DRB Application No.: 09DRB-70289 Project # 1007054
 Project Name: HEIGHTS RESERVOIR ADDITION
 Agent: WAYJOHN SURVEYING Phone No.:

RE: Lots 15 – 19, Block 31, Heights Reservoir Addition

RE: Minor Preliminary/Final Plat of Lots 16-A through 19-A, Block 31, Heights Reservoir
Addition, Project No. 1007054

PLAT OF
LOTS 16-A, 17-A, 18-A & 19-A
BLOCK 31, HEIGHTS
RESERVOIR ADDITION

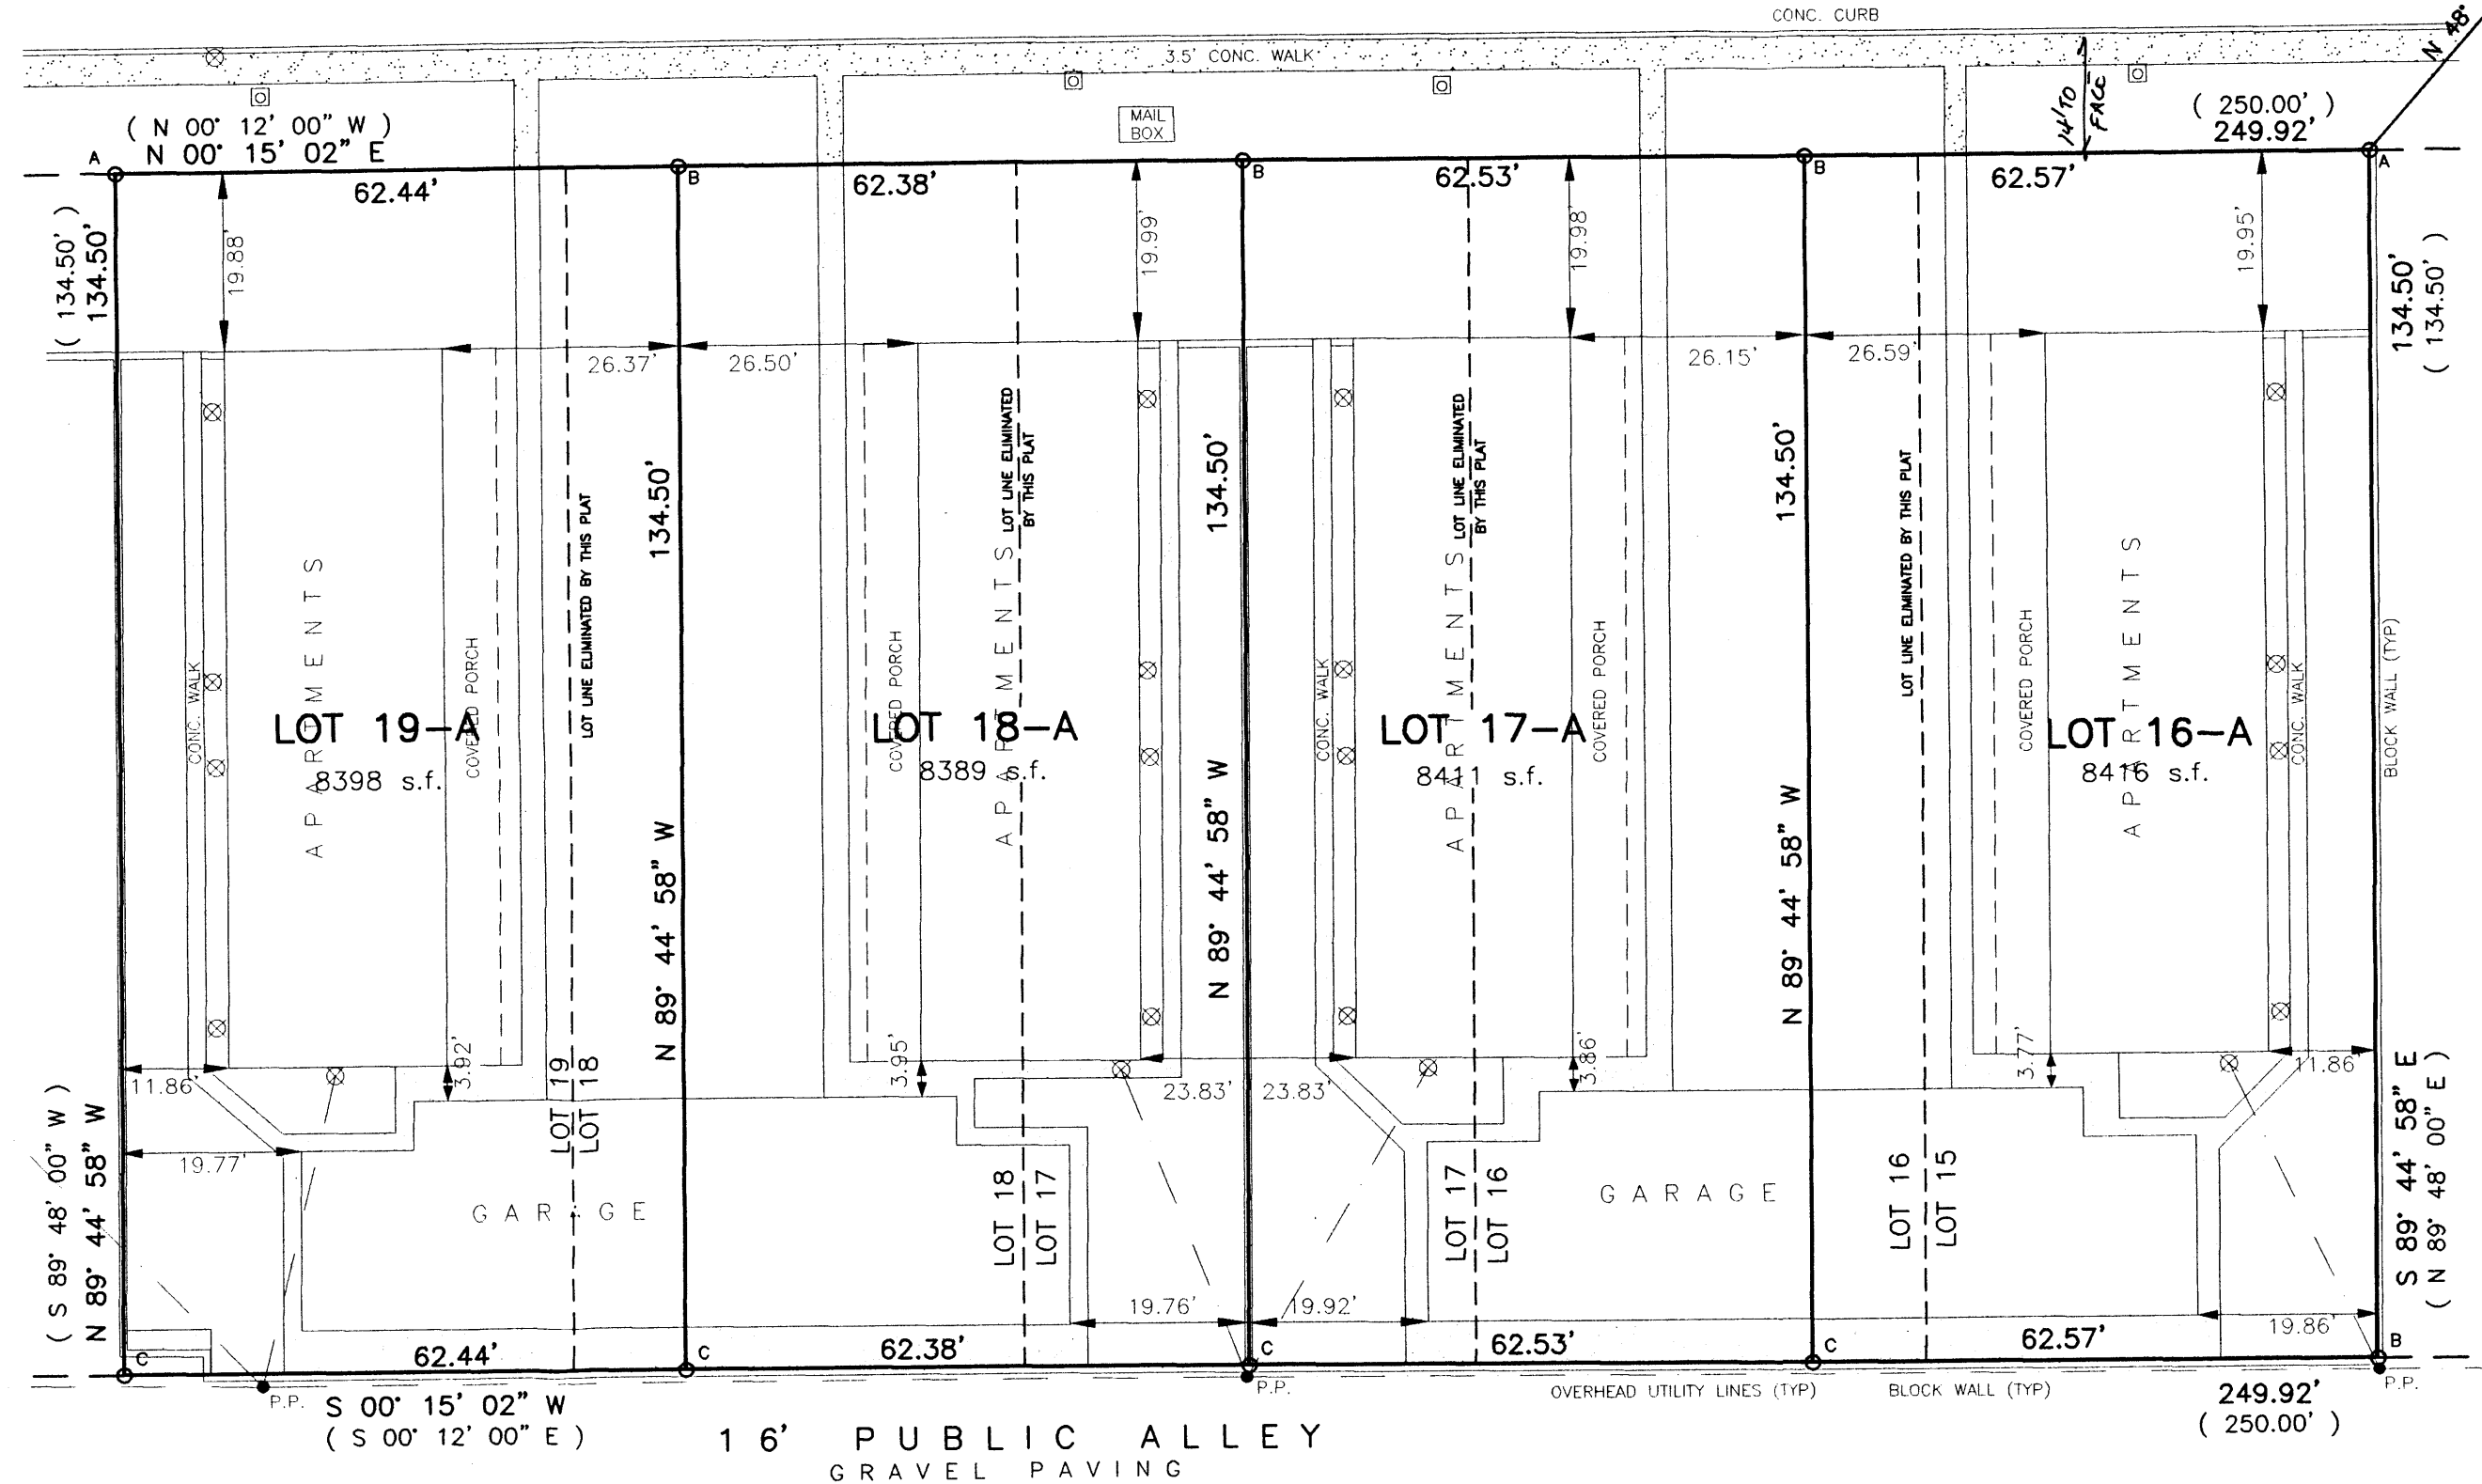
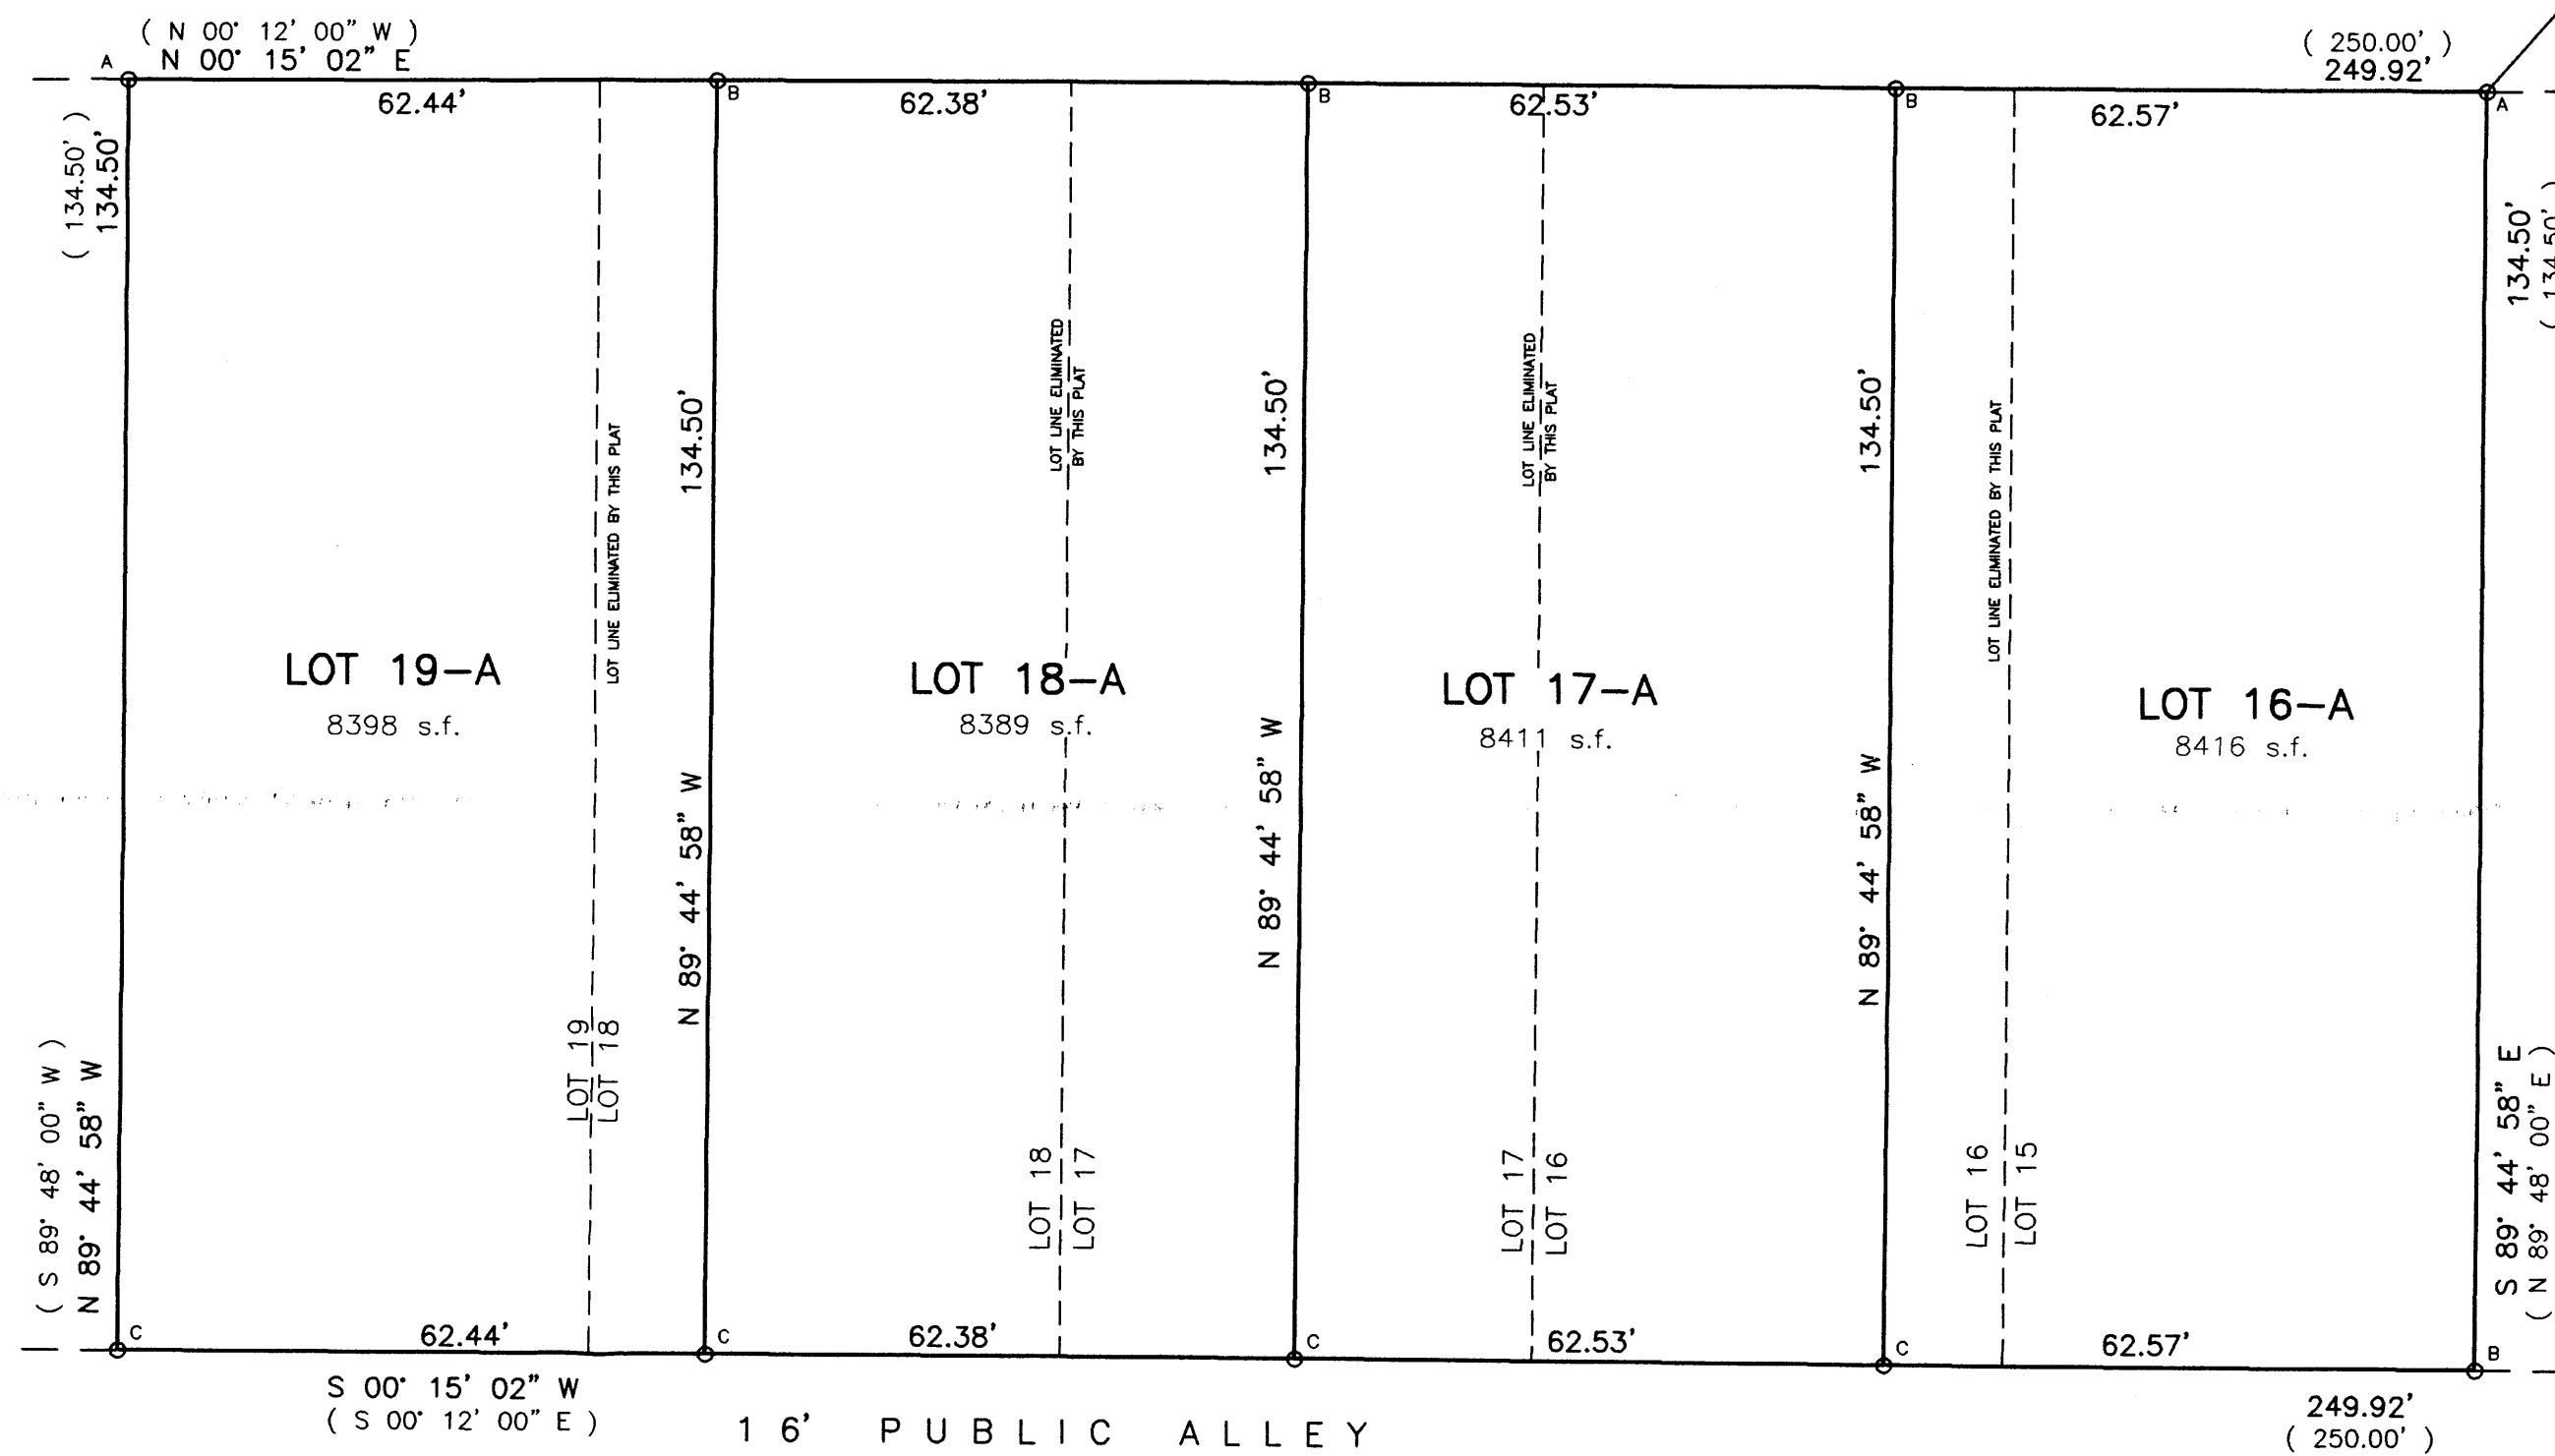
Certification will be needed to demonstrate that the existing garage buildings meet the building code in relation to the proposed lot lines.

For future reference, please do not identify the property's zoning on the plat.

This platting action was submitted April 2008 and all conditions regarding one-hour fire walls have been met. The platting action expired prior to recordation. We are resubmitting to complete this platting action.
